PROJECT: Monrills Crossing ~~Contract Renaming~~

**Memorandum**  
Department of Planning and Development  
Planning Division

**To:** Chair Beal and Members of the Portland Planning Board  
**From:** Sarah Hopkins, Development Review Services Manager  
**Date:** January 10, 2006  
**Re:** January 17 Planning Board Workshop  
**Morrill's Crossing Mixed-Use Development**  
**Traffic Review**

Subject: Peer Traffic Review for Morrill's Crossing/Packard Development Project

Exhibit C Off-Site Improvements

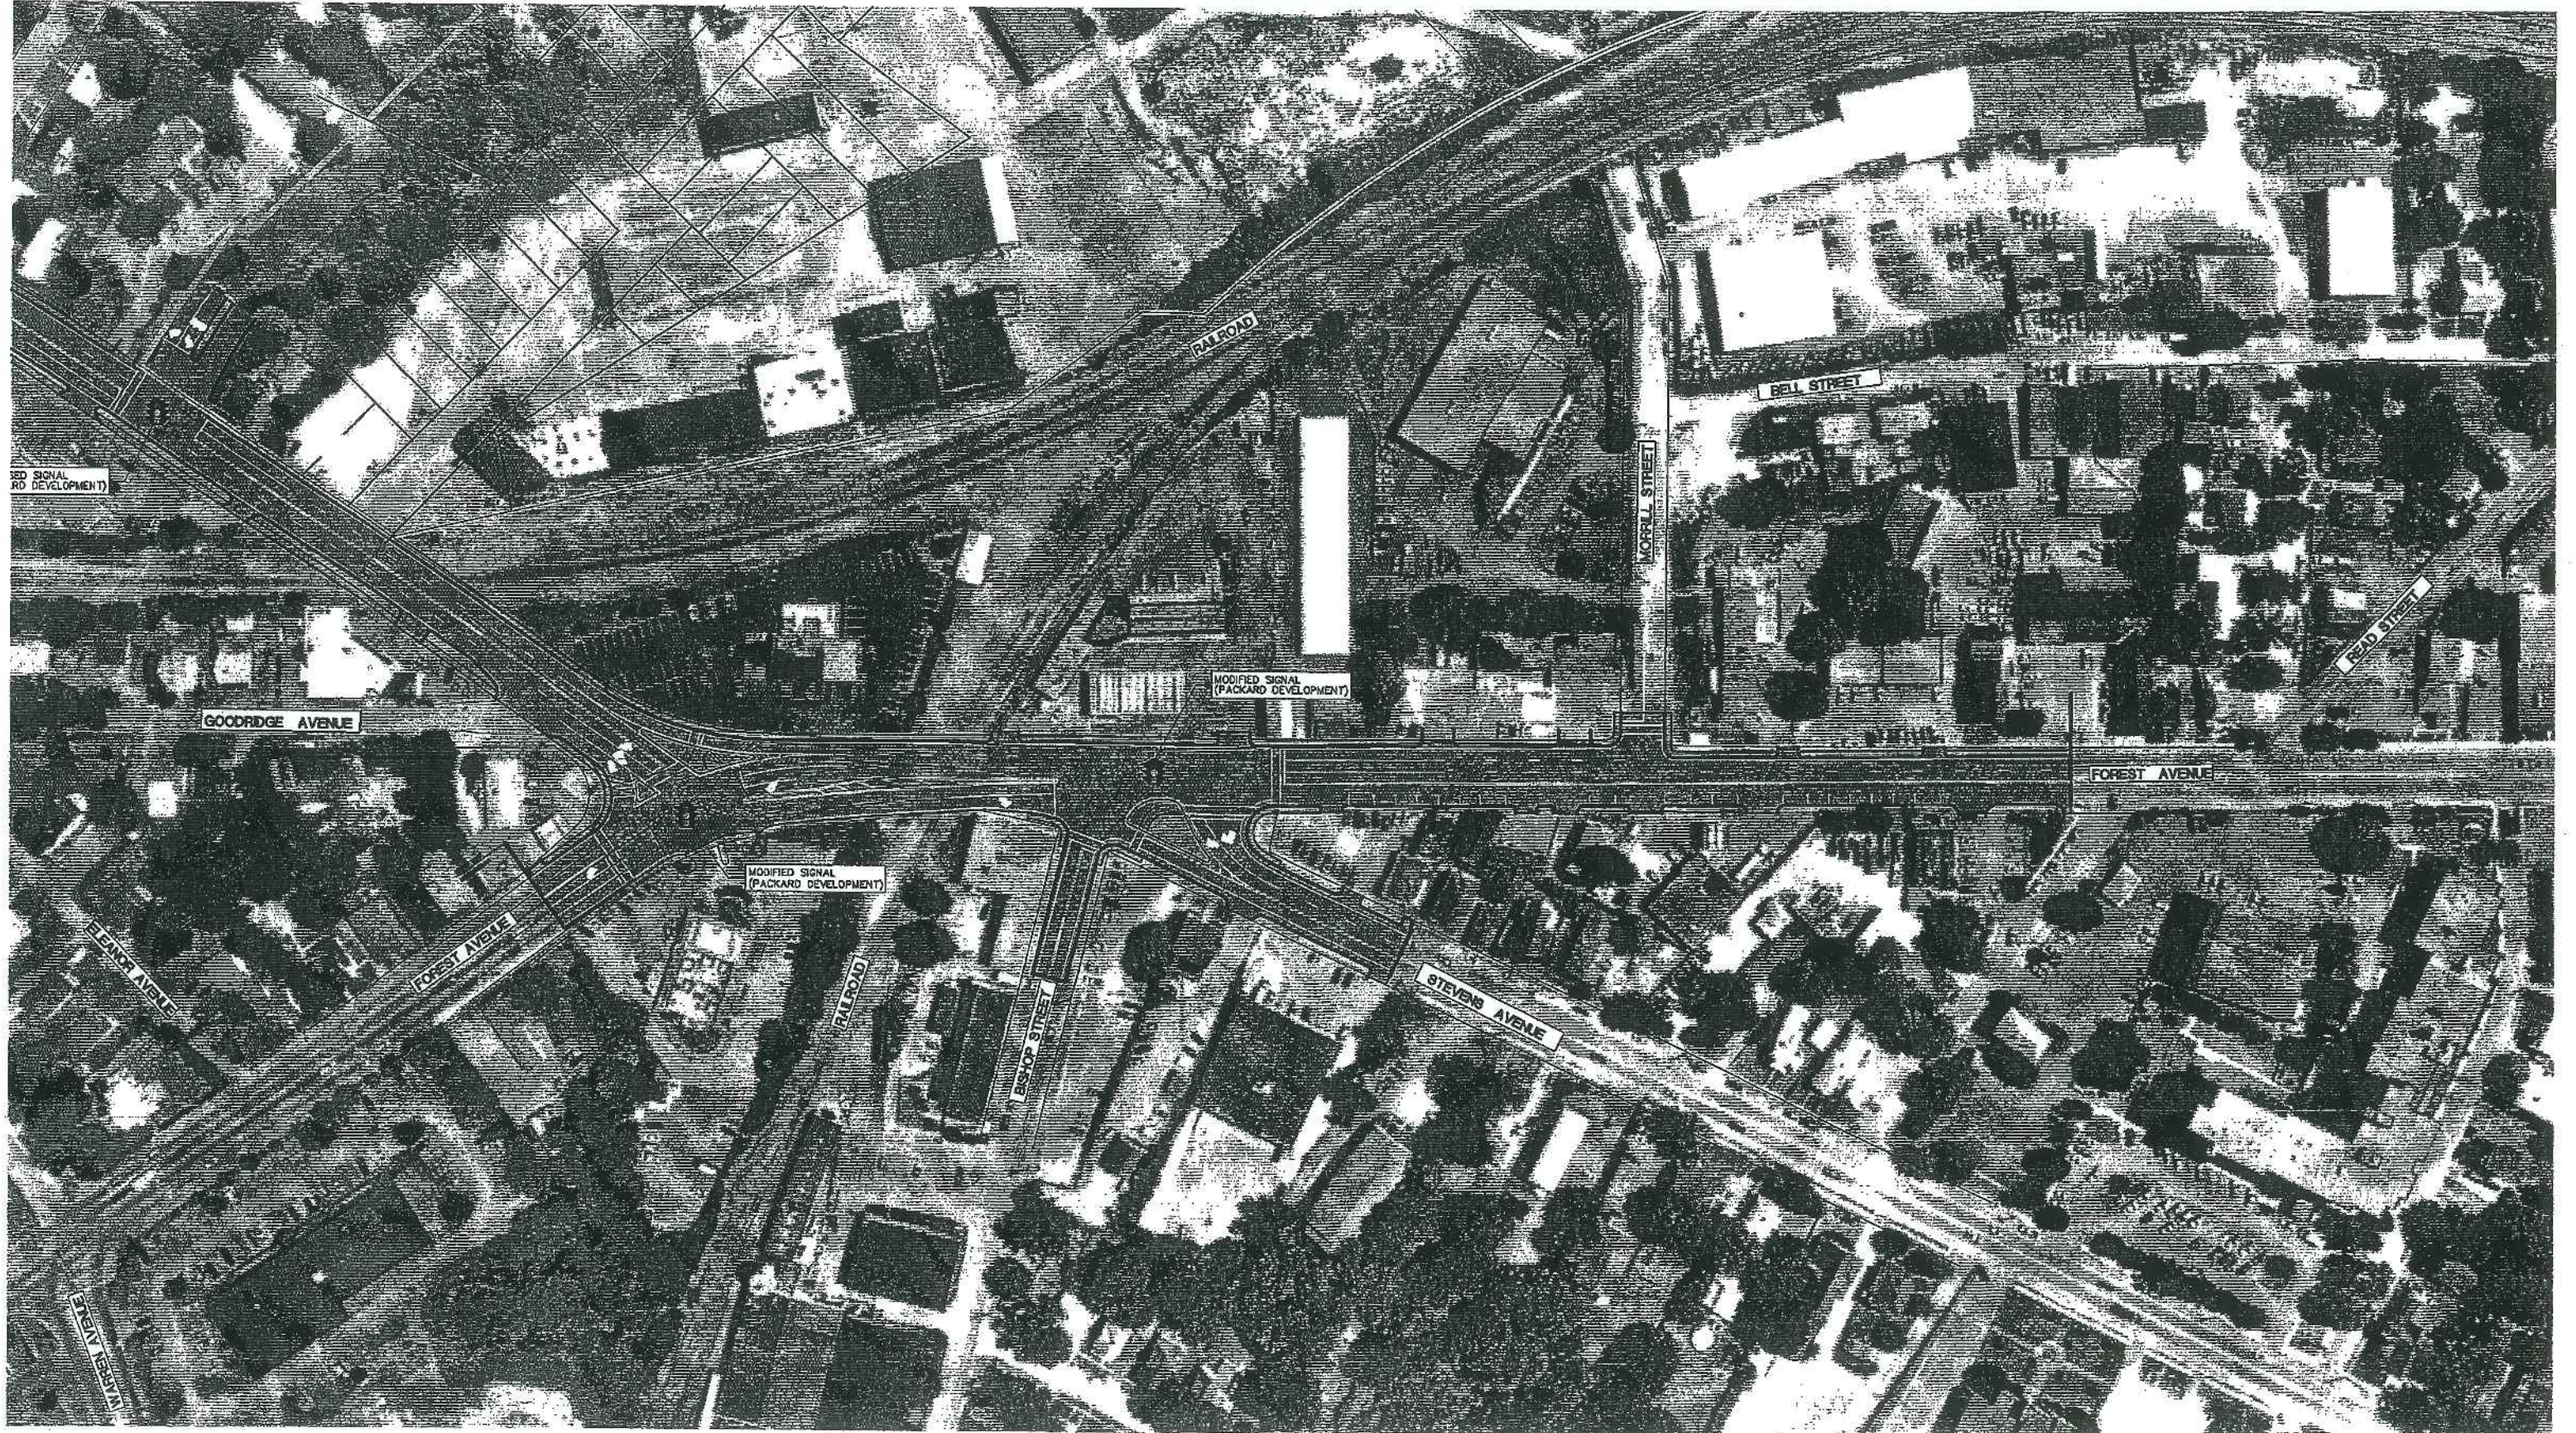
19. The improvement plan should provide details on how Forest Avenue will transition from two lanes to one in the inbound direction.
20. The applicant needs to fully explore and provide alternatives for the provision of four travel lanes on Forest Avenue as it relates to the loss of on-street parking.

3. The applicant presents a mitigation plan to widen Forest Avenue to provide a four-lane roadway section from Allen Avenue to Bell Street. However, the study makes no mention of the impacts of the displaced on-street parking. Further, the widening pushes the roadway edge much closer to the building faces thus limiting the available sidewalk space. There is no mention if this concept can meet the minimum Americans with Disability Act standards for accessibility. There is no mention of fixed objects or doorways that may prevent the ADA standards being met. The viability of this concept needs to be carefully evaluated at this time.
